29th July 2022

Our Ref: *Nelson St Bridge_review*

NELSON STREET BRIDGE CLOSURE

Review of Interchange Access Plan – Alternative Pedestrian & Cycle Access Assessment

Figure 5 Average weekday pedestrian and cyclist volumes at surveyed locations (May 2017)

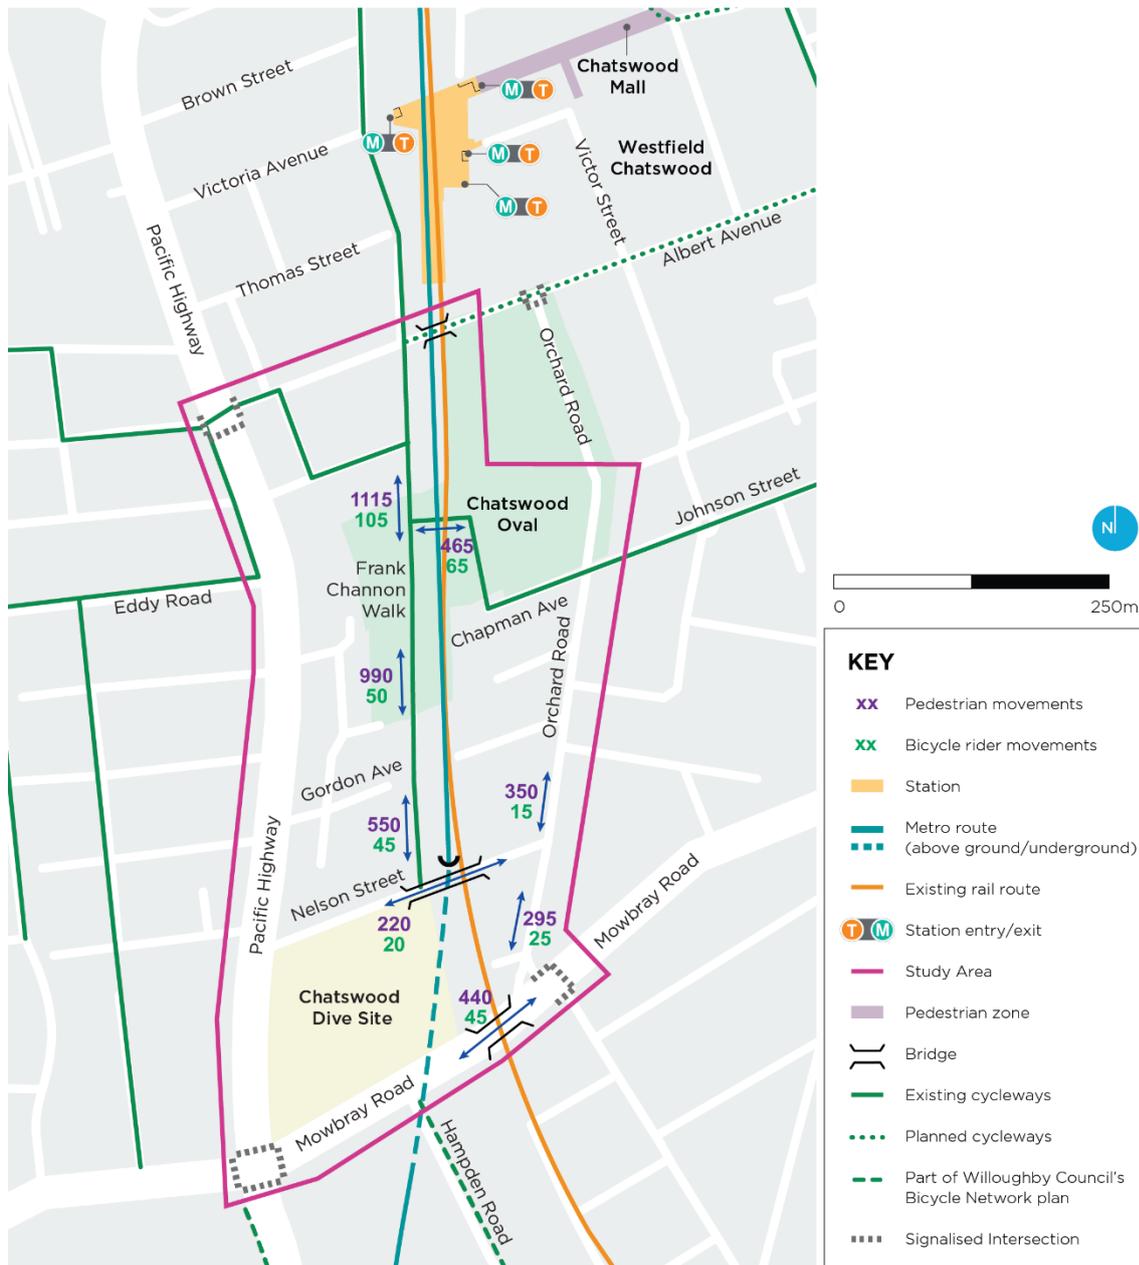
- It is assumed that the weekday pedestrian and cyclist survey volumes in *Figure 5* of the IAP are over the total 16-hour survey period and not maximum or average hourly volumes. It is noted that there are some inconsistencies between the future year demand estimates in *Figure 9* of the IAP and the future year demand estimates from the *TTLG 12 minutes* (page 8).
